Response to Submissions

State Significant Development Application (SSD 9691)

Warehouse and Distribution Facility

28 McPherson Street, Banksmeadow

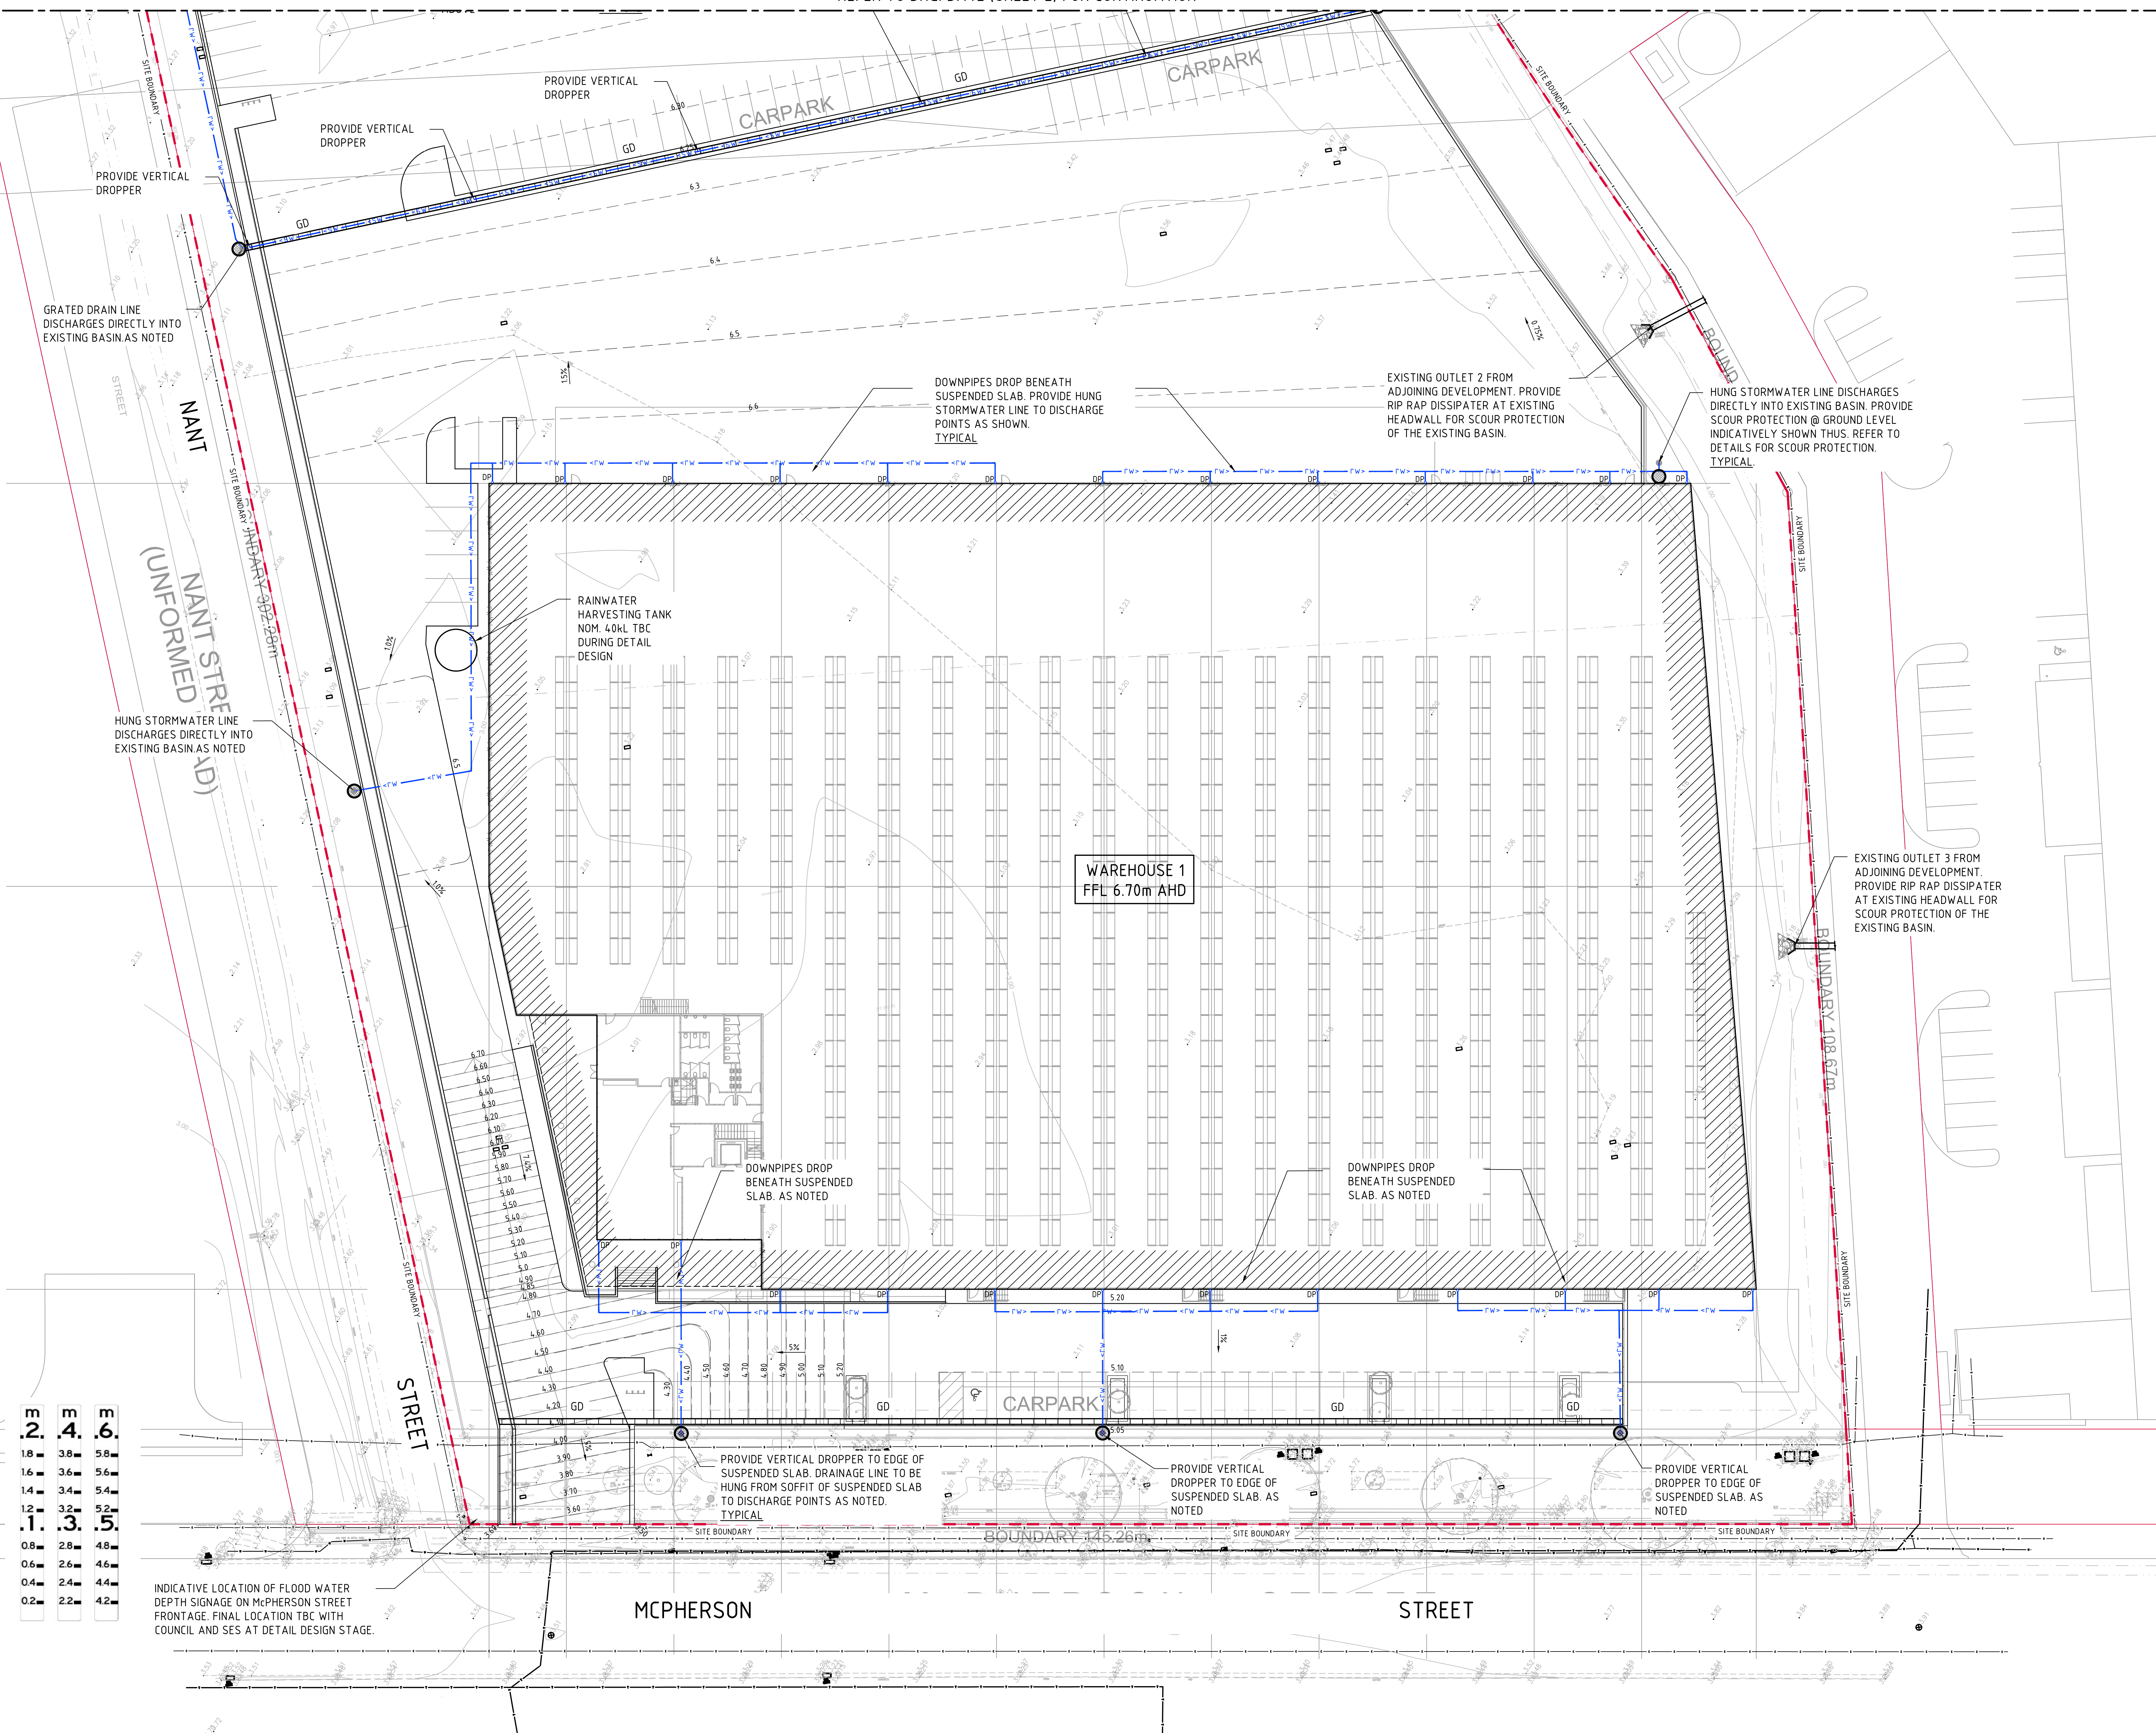
Ref.	Matters raised	Response
<i>Flooding and Stormwater</i>		
B1	<u><i>Flooding</i></u> <i>The applicant is to liaise with Council and the SES to install flood water depth signs on McPherson Street, both at Springvale Drains and at Floodvale Drains, and in front of the property, to warn road users;</i>	The indicative location of the flood water depth sign on the site is provided in Appendix C (drawing Co9349.12-DA41). Signage requirements for Springvale Drain and Floodvale Drain remains the responsibility of Council and the SES.
B2	<u><i>Stormwater Quality</i></u> <i>The flood storage area under the building will be flooded frequently even in a minor rain event. Access to the undercroft area access must be restricted to avoid risk of drowning. Signage is to be provided to warn the employees and visitors.</i>	Access to the undercroft area is restricted to authorised personnel and confined space requirements. The undercroft area will include a mesh steel fence around the perimeter of the underside of the suspended deck to ensure restricted access and allow flood water to enter and exit unimpeded. Signage will be provided to warn employees and visitors at the access gates that the area is prone to flooding. Refer to Appendix C (updated drawings Co9349.12-DA41 and DA42) showing location of proposed signage.
